From: [NectonSubstationAction Messenger](#)
To: [Norfolk Vanguard](#)
Subject: Comments to the Secretary of State's letter on 6th December 2019
Date: 12 March 2020 10:13:38

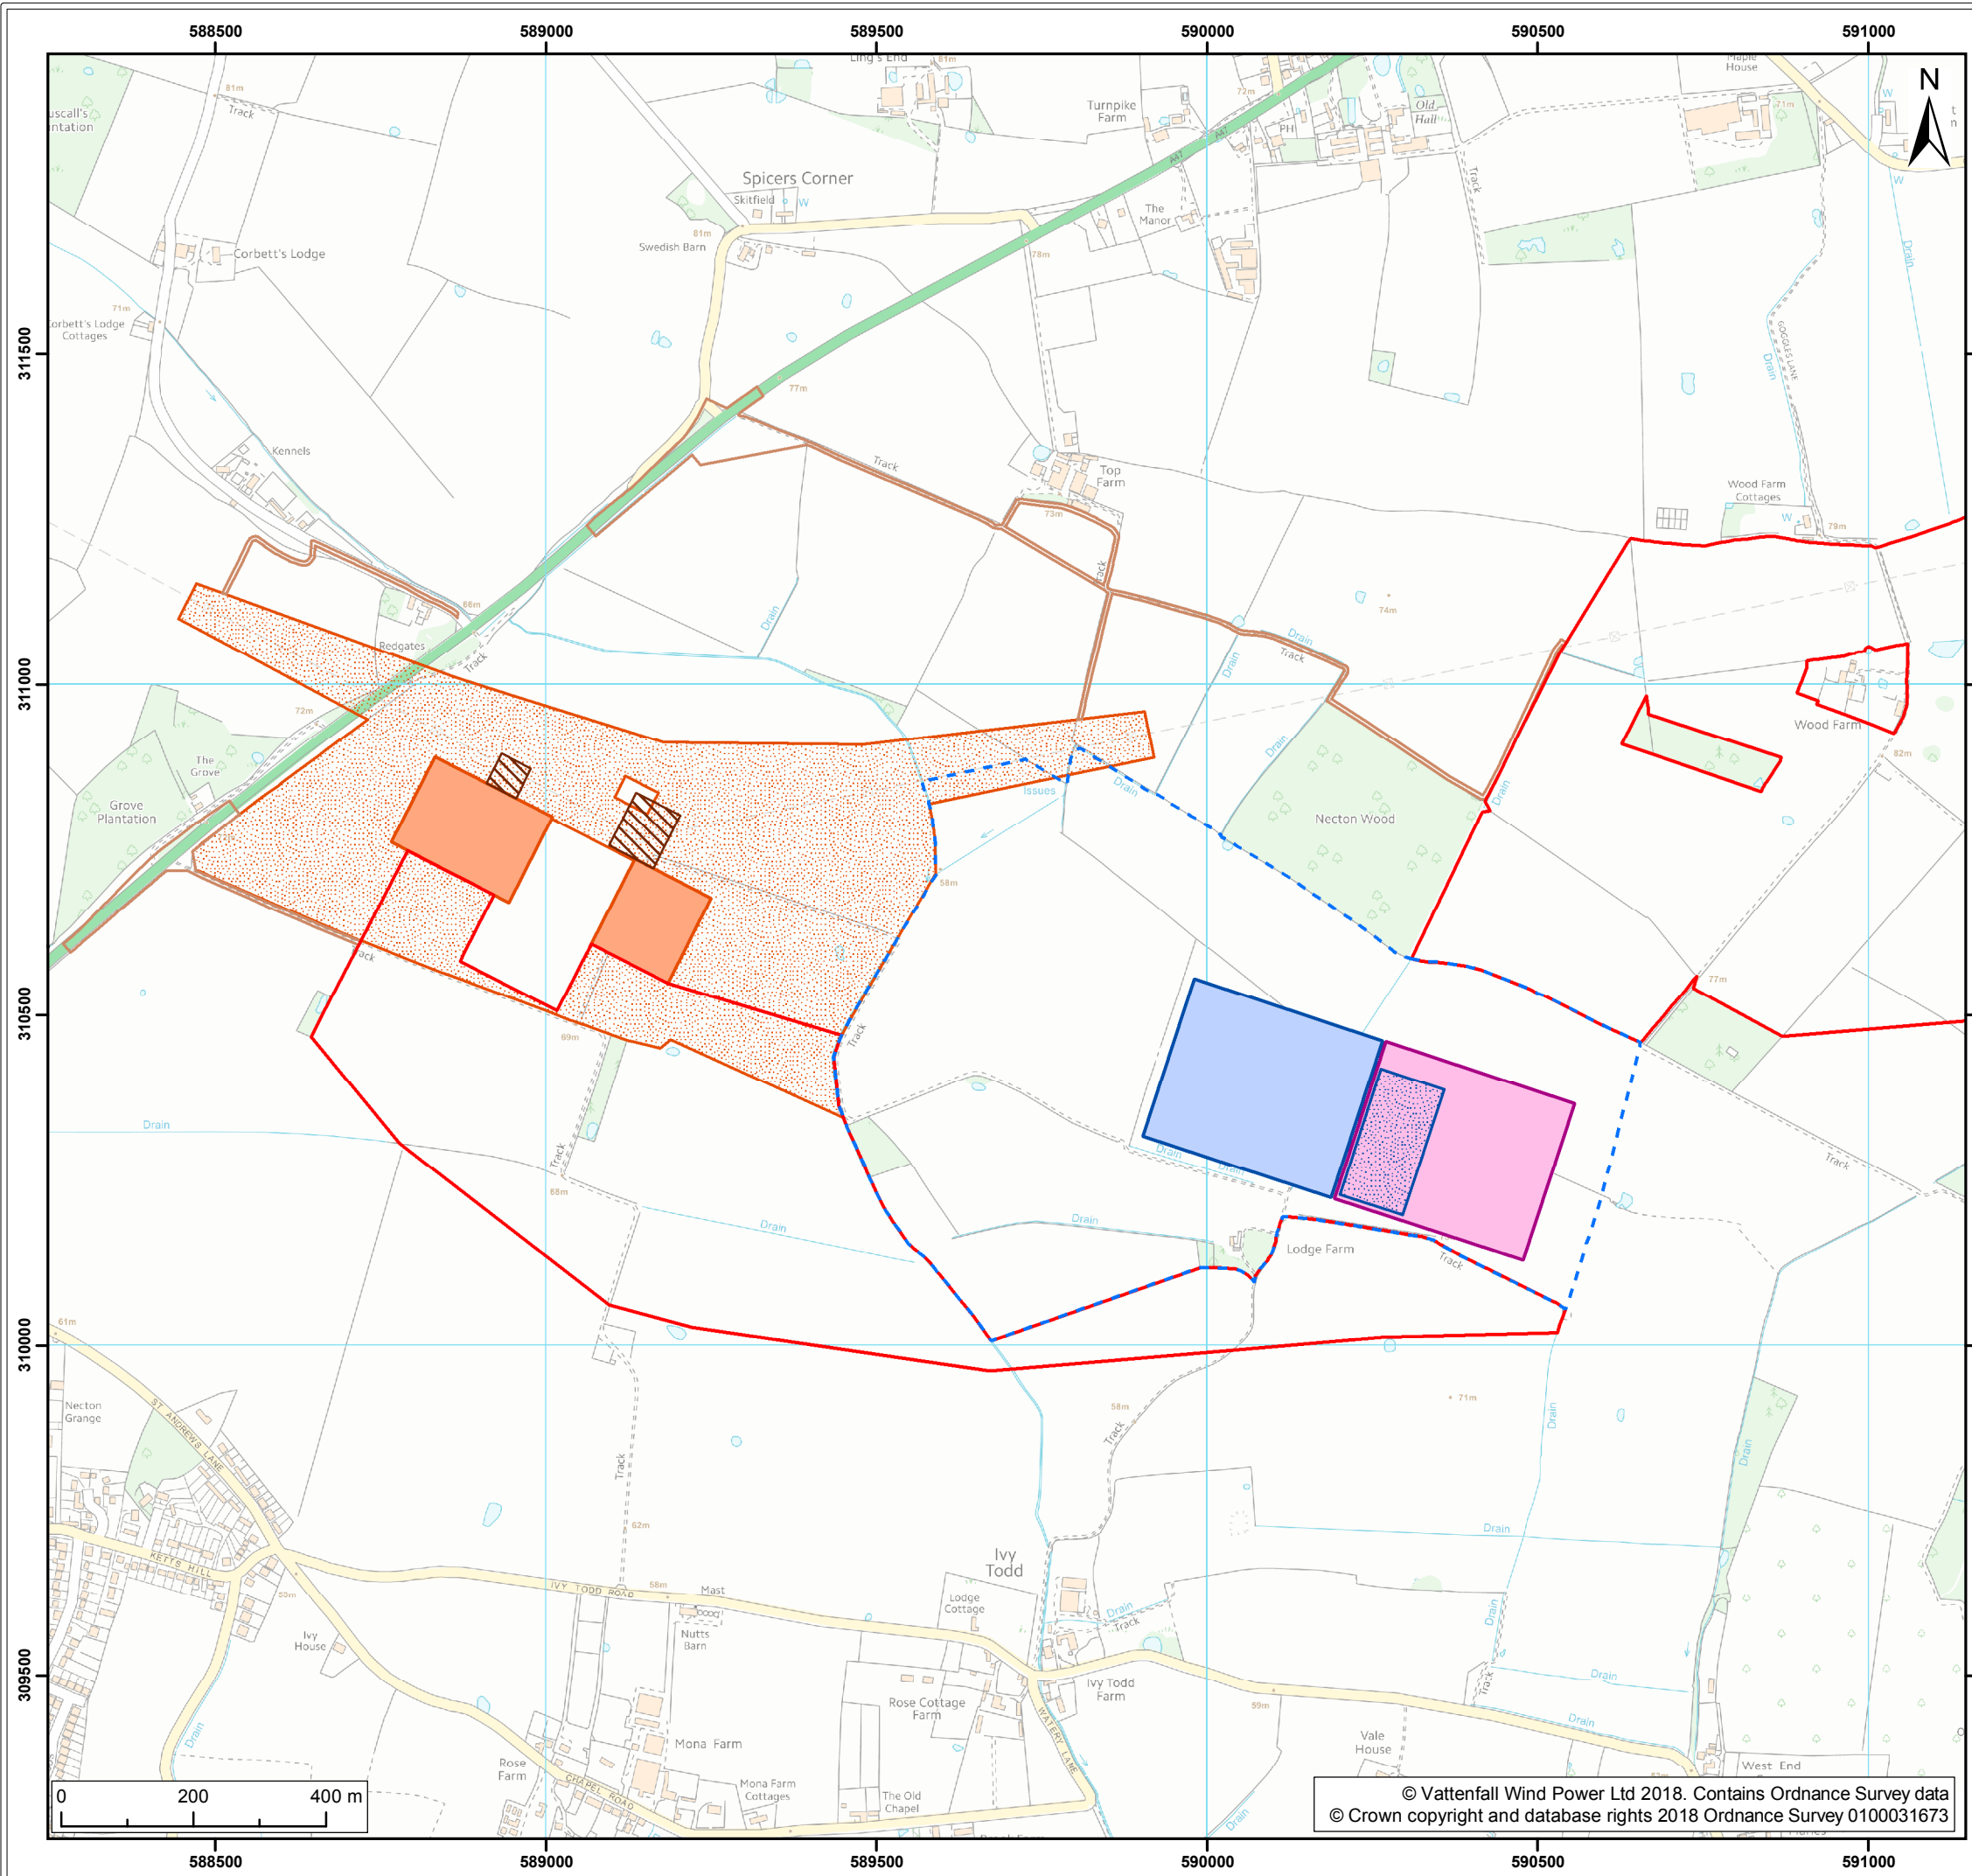
Top Farm site was considered as an alternative site. Is this different from Top Farm being 'reviewed as an alternative site'? If so when was it reviewed?

Can the applicant clarify the heights mentioned in the comparison made between the Top Farm site and the proposed onshore project substation site (proposed site 65m to 70m and Top Farm 65m to 75m), in light of the dDCO secured “existing ground levels” set at 73m AOD (Scenario 1) and 72m AOD (Scenario 2)?

Figure: 29.18b (1 of 2)
Viewpoint 6: A47 Top Farm

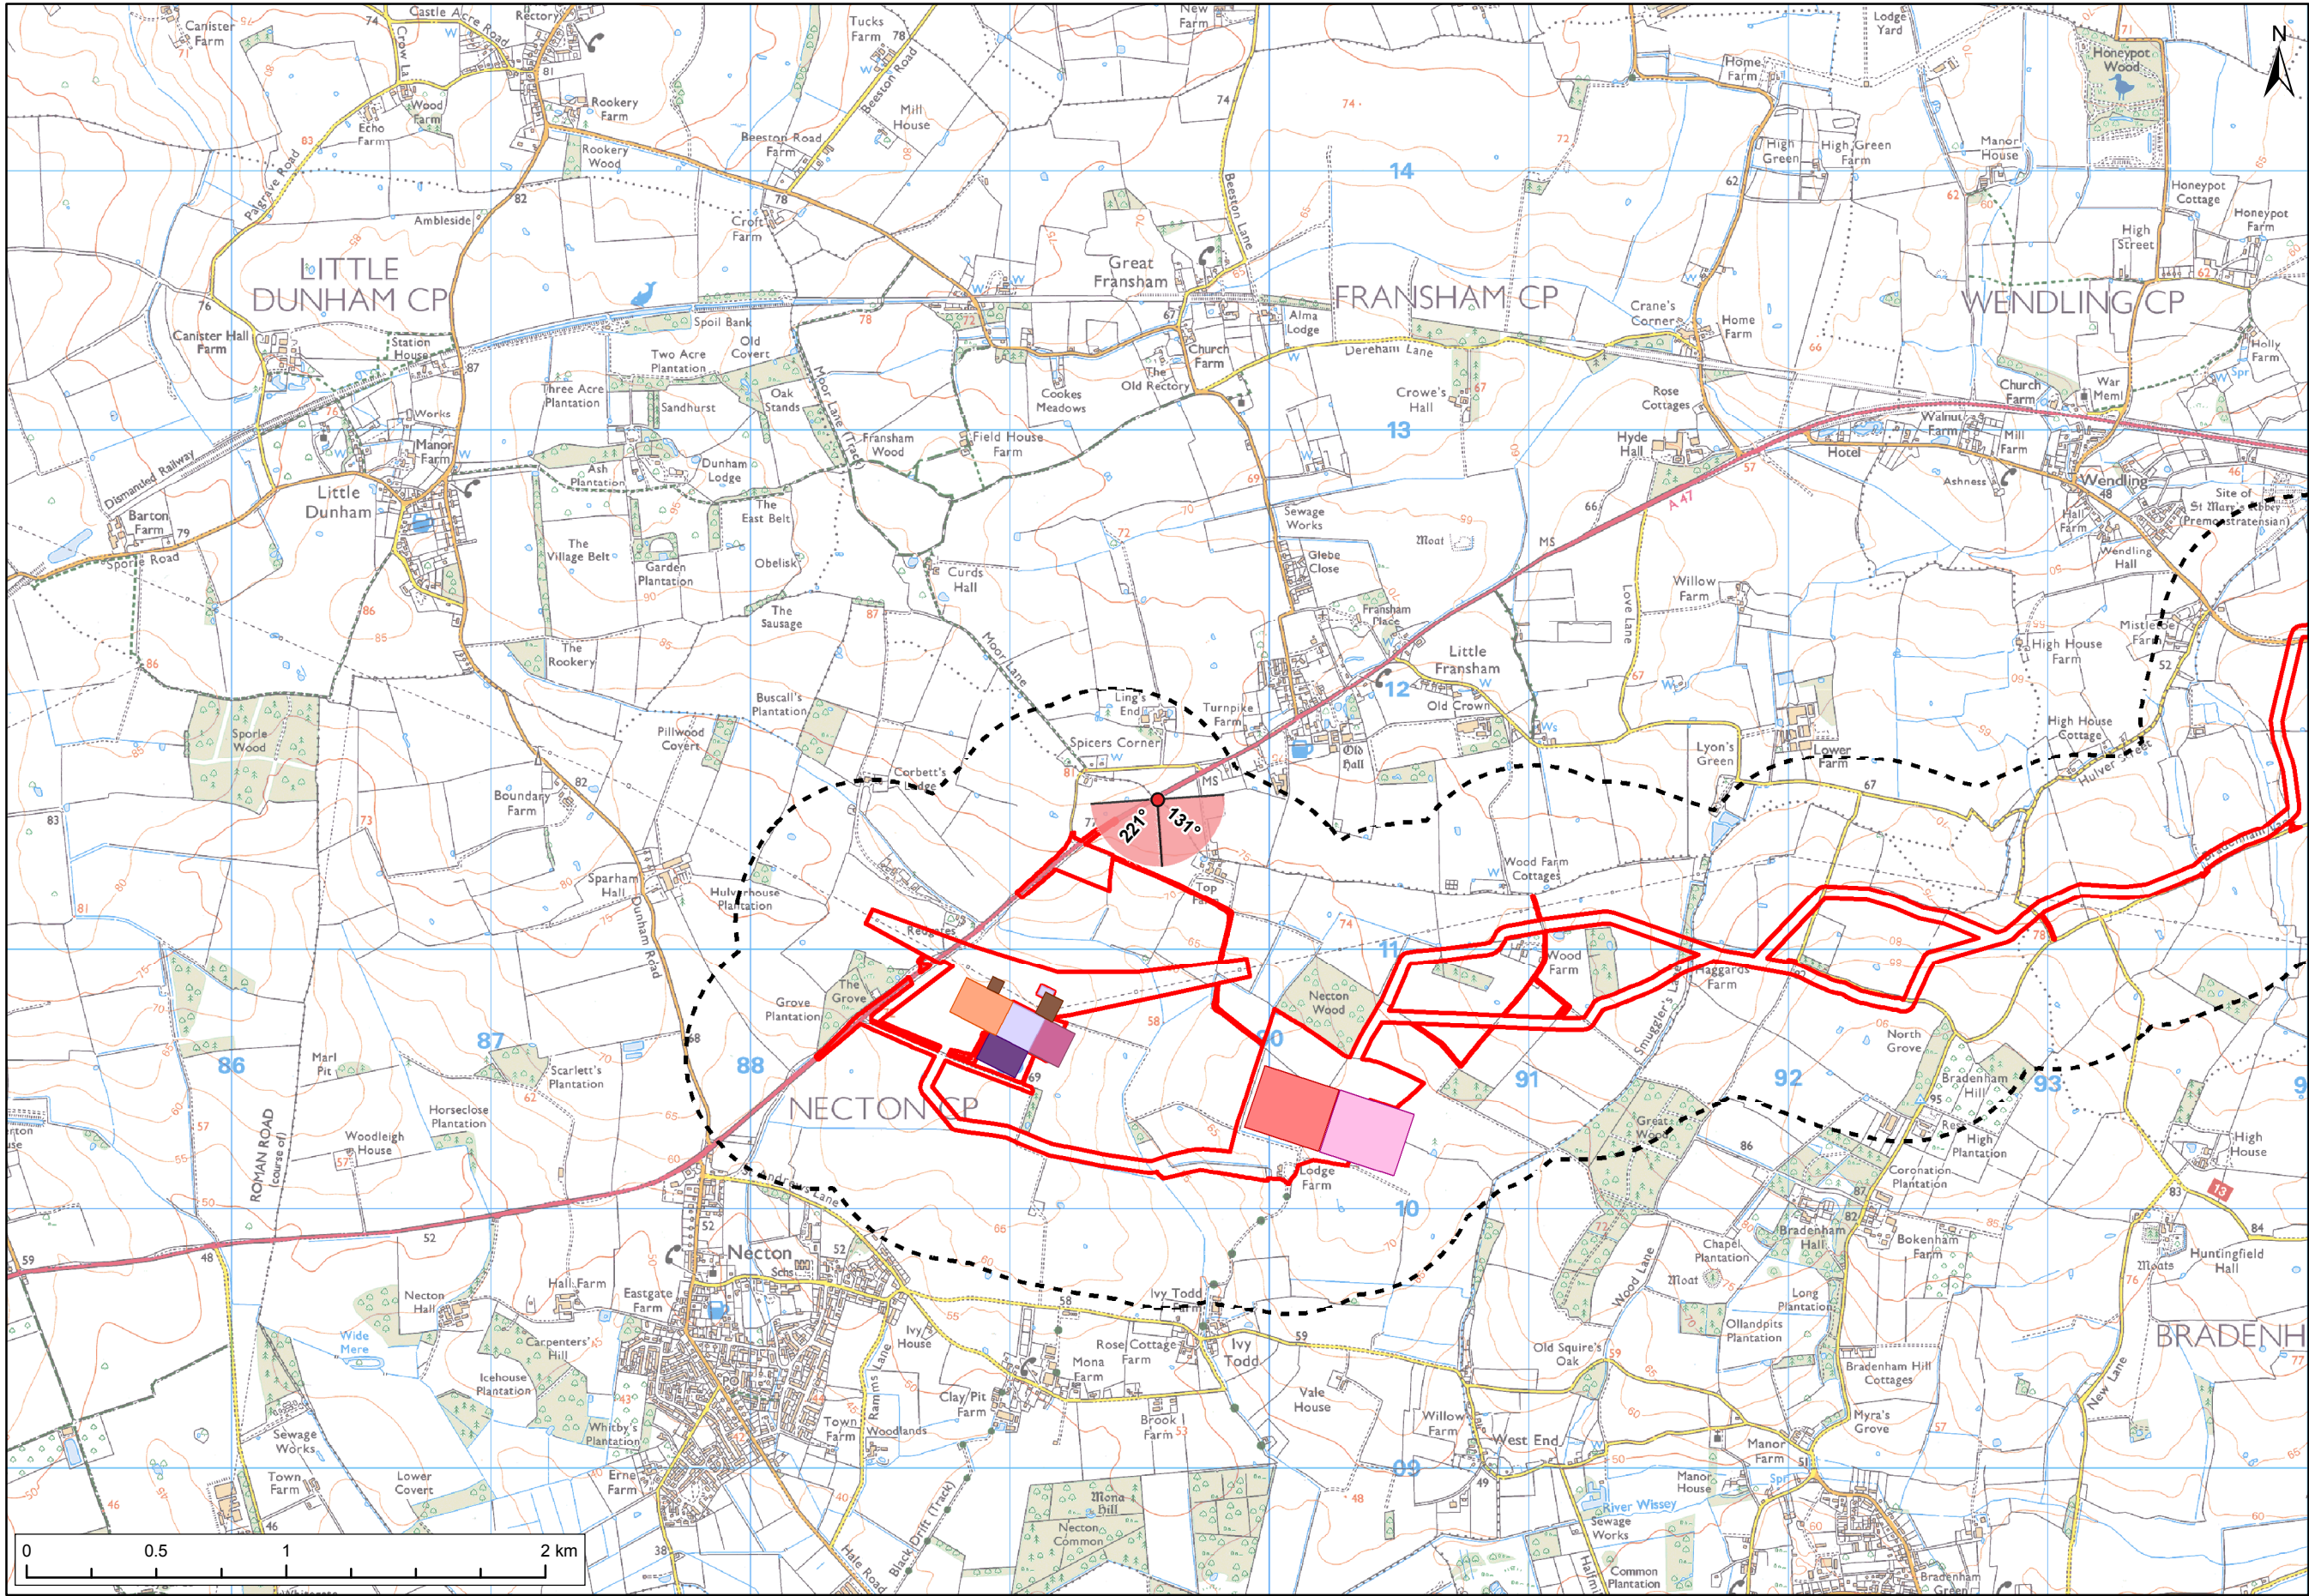
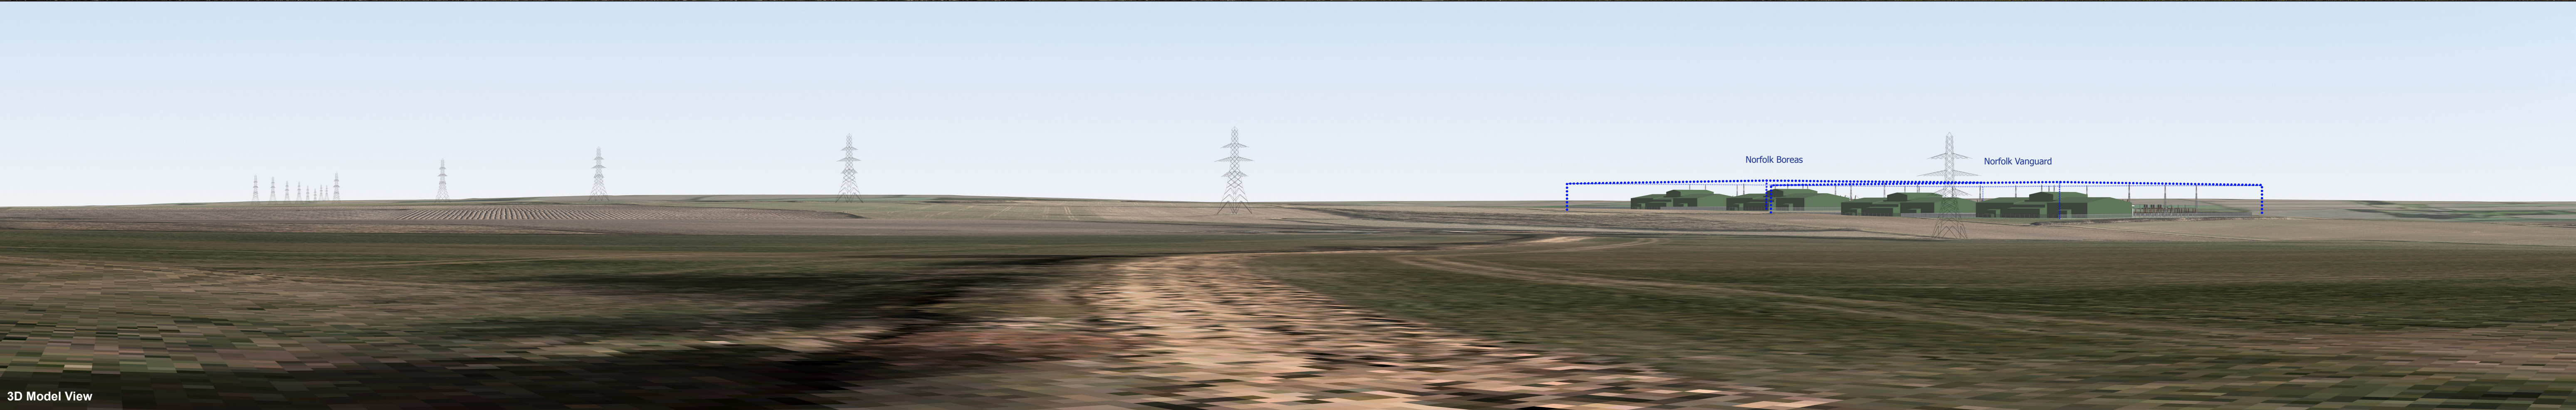
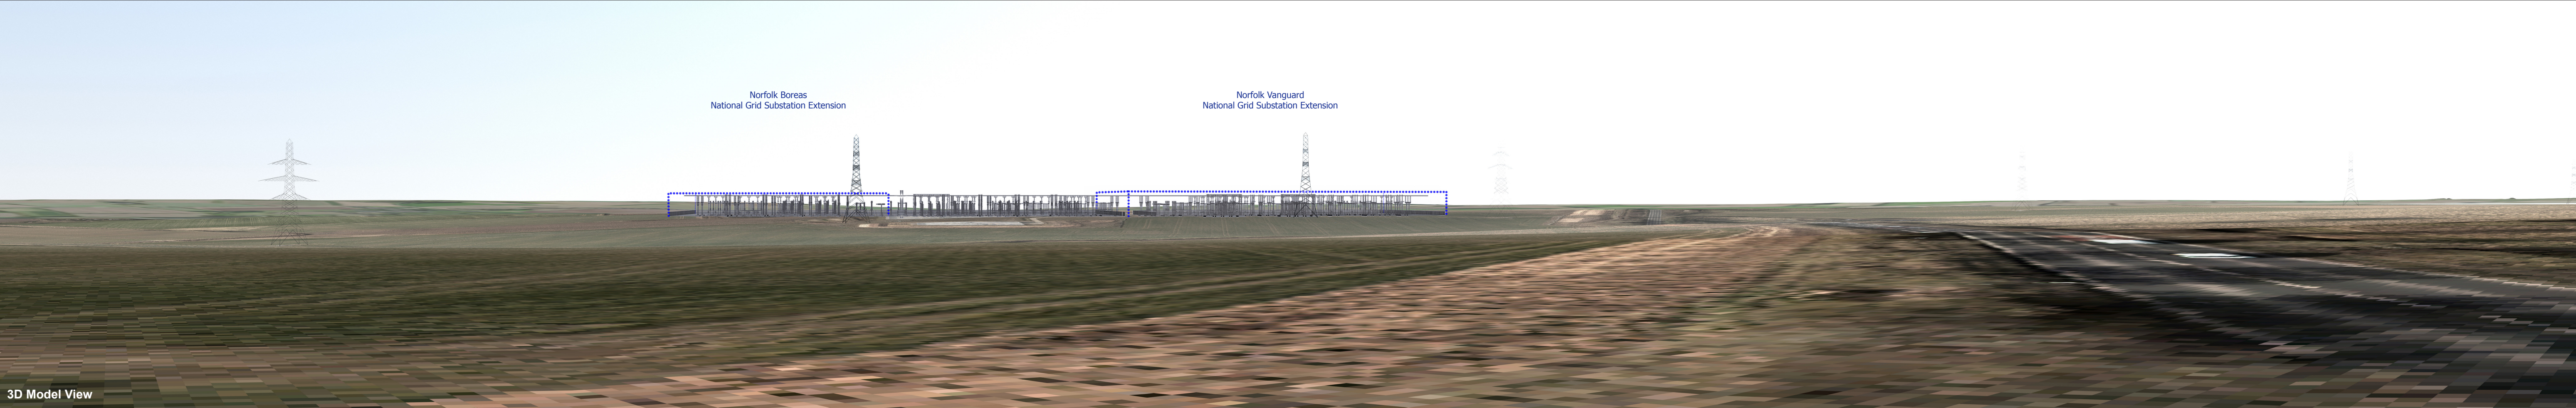
How is it that the motorists along the A47 are assessed as having the same sensitivity as residents represented by other viewpoints?
